WELWYN HATFIELD COUNCIL – DEVELOPMENT CONTROL
DELEGATED REPORT

APPLICATION No:	S6/2010/1169/AD
------------------------	------------------------

This application seeks advertisement consent to create two new hoarding signs, one double sided post mounted (Hoarding A) and one single sided wall mounted (Hoarding B).

A. 1no. DOUBLE SIDED TIMBER FRAMED PLYWOOD HOARDING MOUNTED ON STEEL POSTS  
 TIMBER FRAME AND POSTS PAINTED BLACK, PLYWOOD PAINTED GLOSS WHITE.  
 GRAPHICS WILL COMPRISE PRINTED POSTERS APPLIED TO FACE OF HOARDING.  
 POSTERS WILL CHANGE. (EXAMPLE SHOWS TYPICAL MOTOR TRADE POSTER)

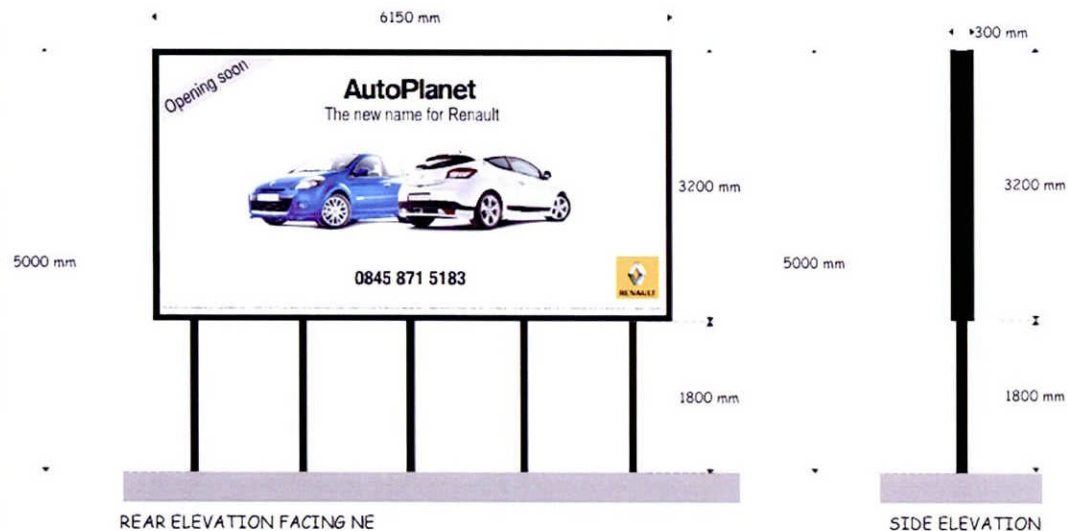
Hatfield Town Council object to the size of the hoardings considering both to be a
distraction to road users.

The proposed signage comprise of two hoarding boards, one wall mounted and one post mounted. The post mounted sign will be located close to Comet Way along the boundary wall with the drive thru to the north of the site. The hoarding board measures 4.9 metres from ground level at a width of 6.1 metres. Taking into consideration the open nature of this area with office and commercial buildings set back approximately 20-30 metres from Comet Way, the post mounted hoarding board will appear visually prominent in the streetscene and therefore will not positively contribute to the open character of the surrounding area which contravenes with policy D2 of the Welwyn Hatfield District Plan, 2005. The adjoining food outlet is a Grade II Listed Building. The location of the hoarding and its size when viewed from certain directions does have an impact on the setting of this part of the listed building. Whilst the main considerations in relation to an advertisement application are the impact on visual amenity and highway safety, this can include wider factors such as conservation areas, natural landscapes and listed buildings. The signage because of its size affects the setting of the adjoining Grade II listed building and overall the visual interests of its surroundings.

Overall, the proposed signage combined with the advertisement signs which exist already on site would be overly prominent and poorly sited, which would be to the detriment of the visual amenity of the street scene.

1. By virtue of the scale, size and siting of the proposed free standing hoarding sign this would result in a detrimental impact on the character and appearance of the area and visual interests of its surroundings, including the setting of the adjoining Grade II listed building. The proposal is therefore contrary to PPS5, PPG 19 and Policies GBSP2, D1 and D2 of the Welwyn Hatfield District Plan 2005.

HOARDING FIXED TO SE ELEVATION OF BUILDING

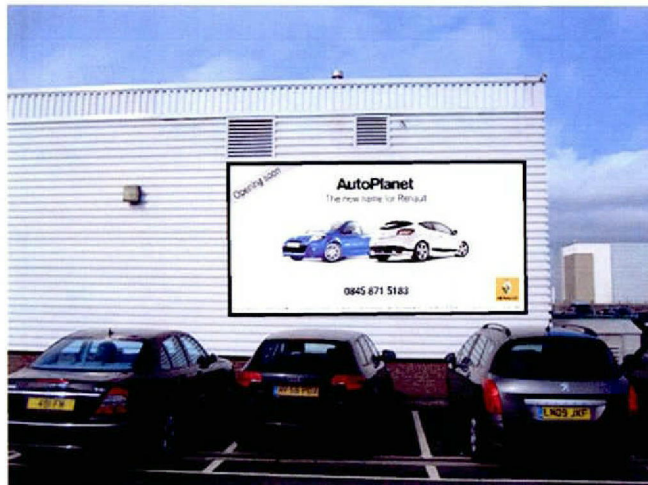
The hoarding board which is wall mounted on the main building measures 3.2 metres in height and 6.2 metres in width. No advertisements currently exist on this building. This hoarding board is not considered to appear overly prominent when viewed in relation to the building as it will be subordinate in scale and taking into consideration the building measures approximately 35 metres from the edge of Comet Way it will not appear overly prominent within the streetscene.
